MEMORANDUM

SUBJECT: **On-Call Contract #17-067H-1; PO # 8115428**
Traffic Impact Study Reviews
Task Order #6: Lorson Ranch Commercial TIS Review (P2211)

This memorandum provides a list of comments on the June 2022 Lorson Ranch Commercial Traffic Impact Study (TIS) prepared by Matrix Design Group for The Landhuis Company. Our comments are based on requirements provided in the County's Engineering Criteria Manual (ECM), Appendix B.

Figure 7. Trip Distribution

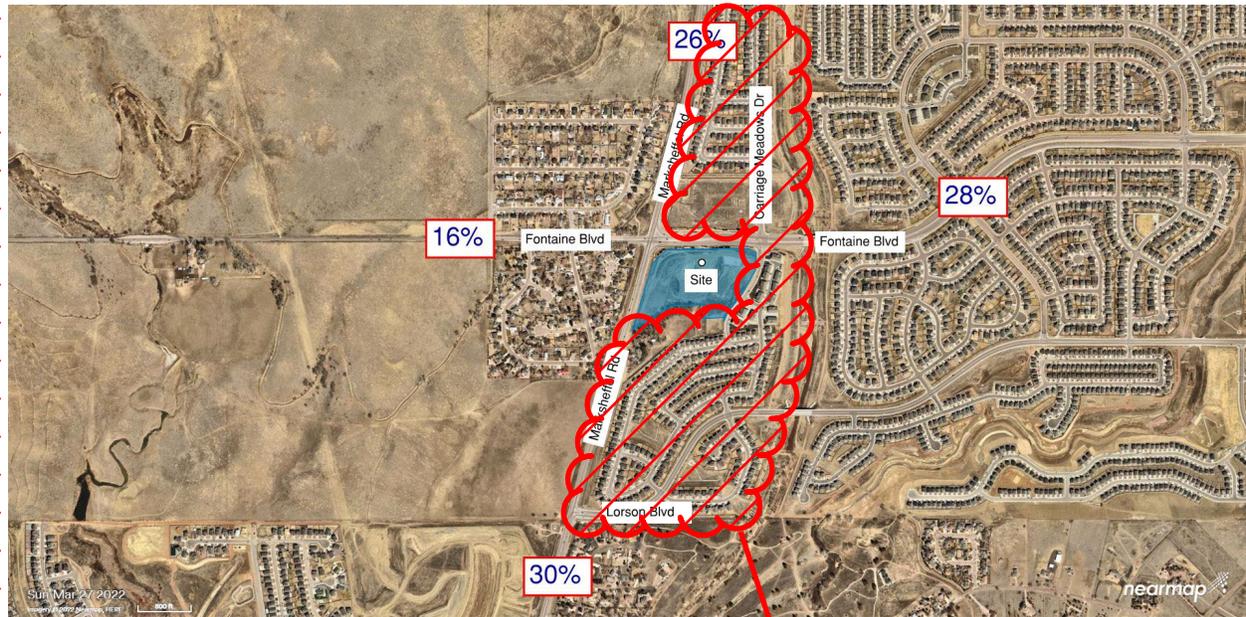
- c. The trip distribution appears to be based solely on existing daily traffic volumes presented TIS Figure 5. Given the growing nature of this area, other trip distribution data should be considered, such as information from the various studies listed on TIS page 9. Further, distributions between other portions of Lorson Ranch and the commercial site should be considered (particularly north and south along Carriage Meadows Drive).

Figure 8. Roadway Classification

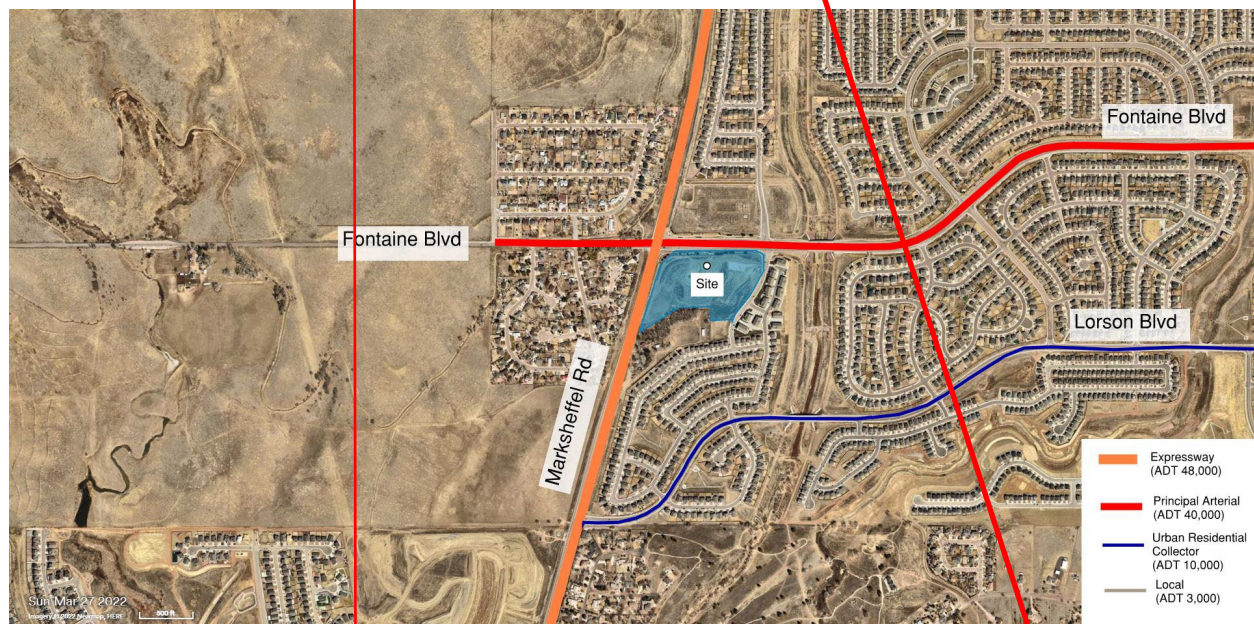
4. We recommend disapproval of the deviation request for a new access along Fontaine Boulevard from a traffic perspective.
- a. The access serves less than 160 vehicle trips (combined entering and exiting) based on Figure 9 and Figure 10 in the TIS.
